From: Anita Gardner <Anita.Gardner@arun.gov.uk>
Sent: 16 July 2020 09:08
To: Planning.Responses <Planning.Responses@arun.gov.uk>
Subject: FW: Planning Consultation on M/28/20/DOC

Engineers comments;

The level of detail supplied is currently insufficient to enable the discharge of conditions 11, 13 or 14.

Figure 1
Groundwater Level at all Boreholes

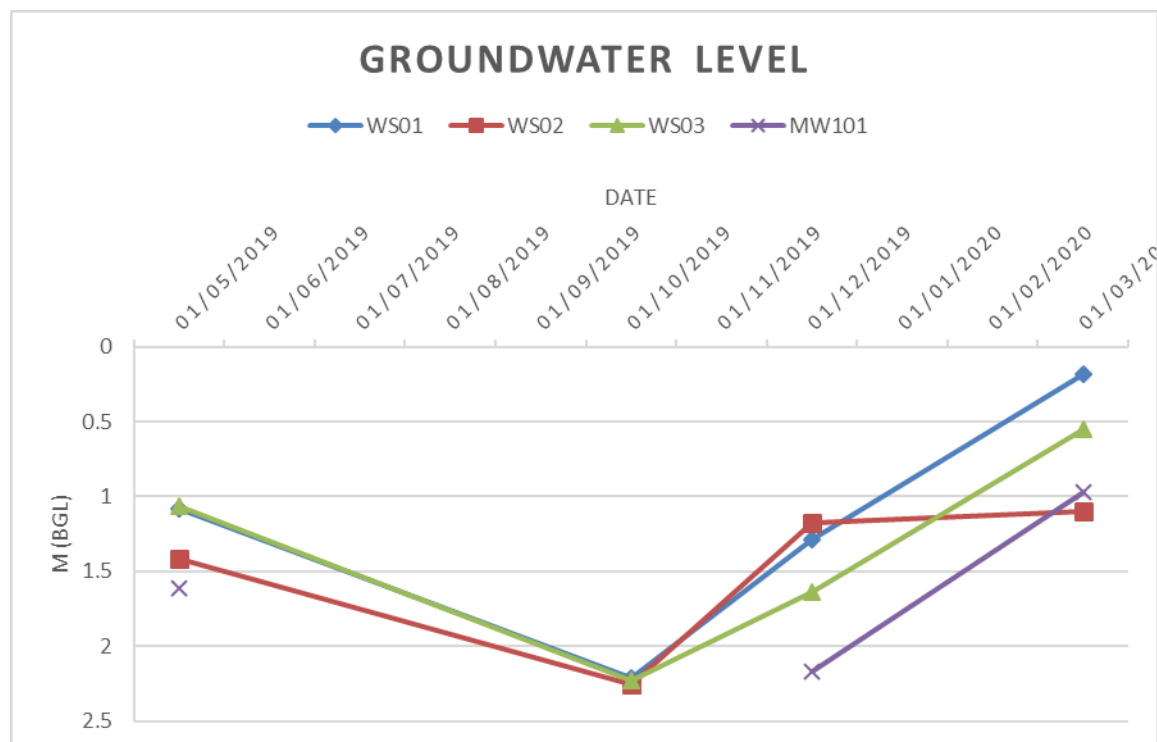
Firstly, we need to be sure that shallow infiltration is not possible, as part of an overall scheme. Please provide a plan showing all the groundwater monitoring point locations and the monitoring results for all, not just WS02. Achieving 1m freeboard between the base of structures and the peak recorded groundwater level is not a requirement in this particular area, so long as the base is above the peak recorded level. This information will dictate as to whether shallow winter infiltration testing will be required.

Figure 4
Route 1 Plan and Section AA'

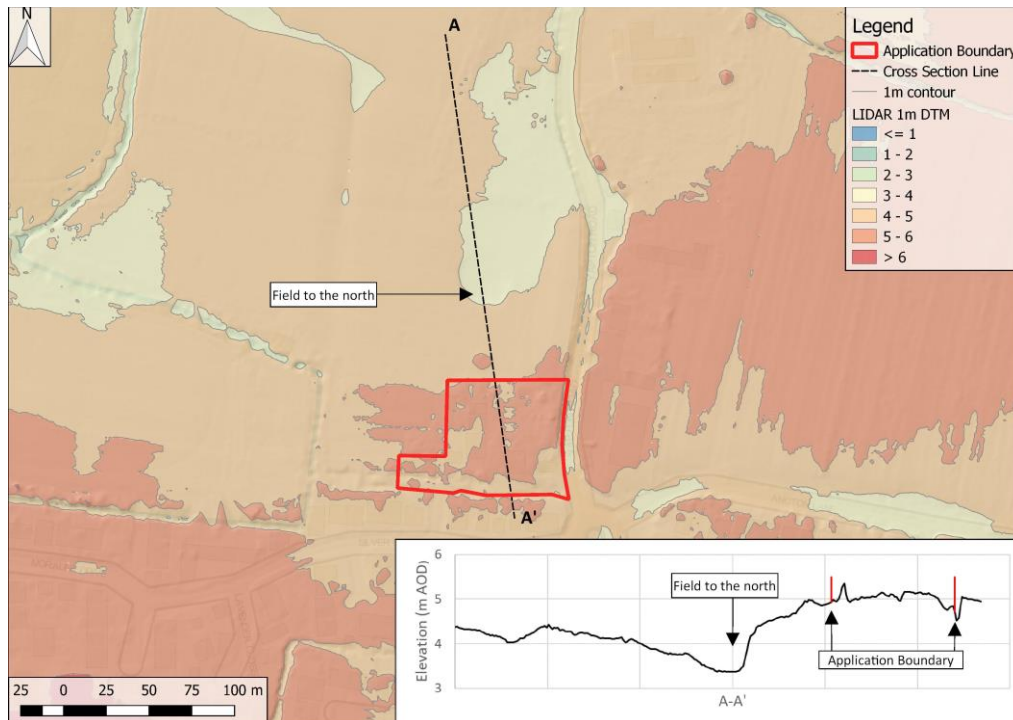
The applicant should also provide topographical evidence to show that no overland/exceedance run off flows from the field to the north will have any detrimental effect on the development/suds.

Site: YAPTON POULTRY FARM
Project: MIDDLETON RESIDENTIAL
Date: 01/07/2020
Drawing: SITE VISIT DISCUSSION
APPENDIX 02

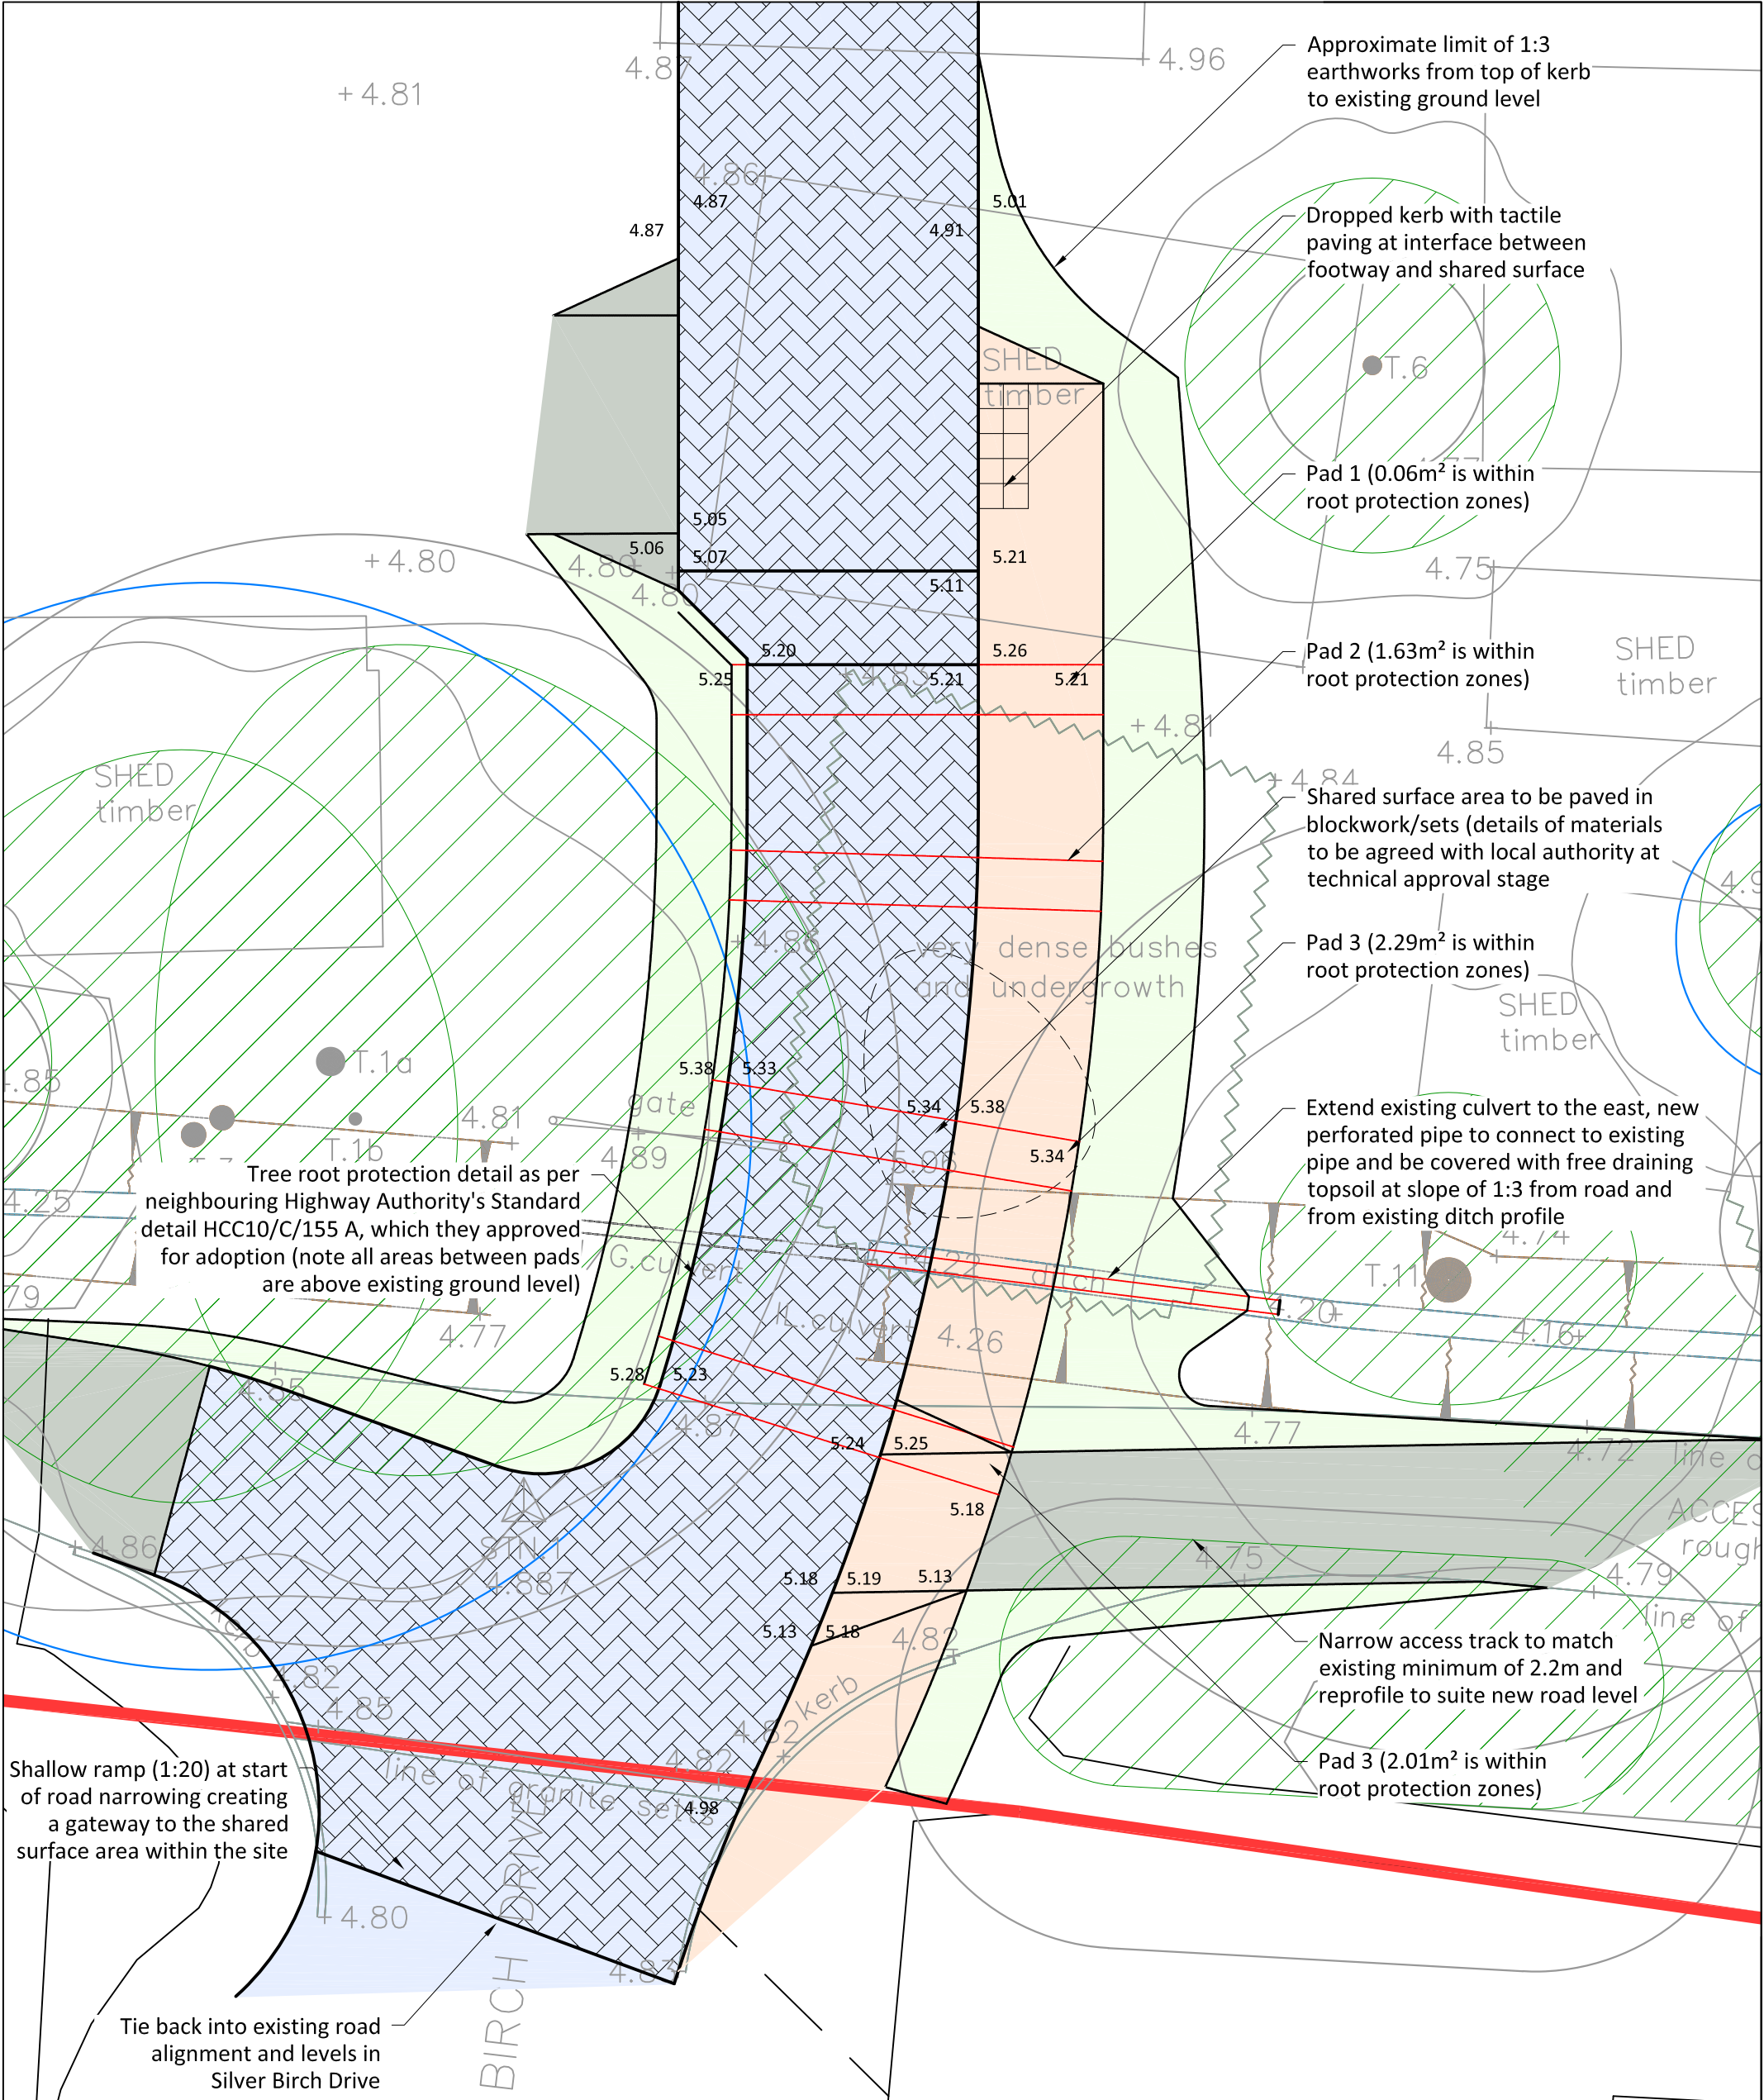
Regarding the ditches on the southern boundary, it is very likely that these will need improvements and I suggest a meeting takes place on site to look at these. Land Drainage Consent will be required for any alterations to them, including culverting and any discharge structures. This will all need to be fully detailed on the drawings.
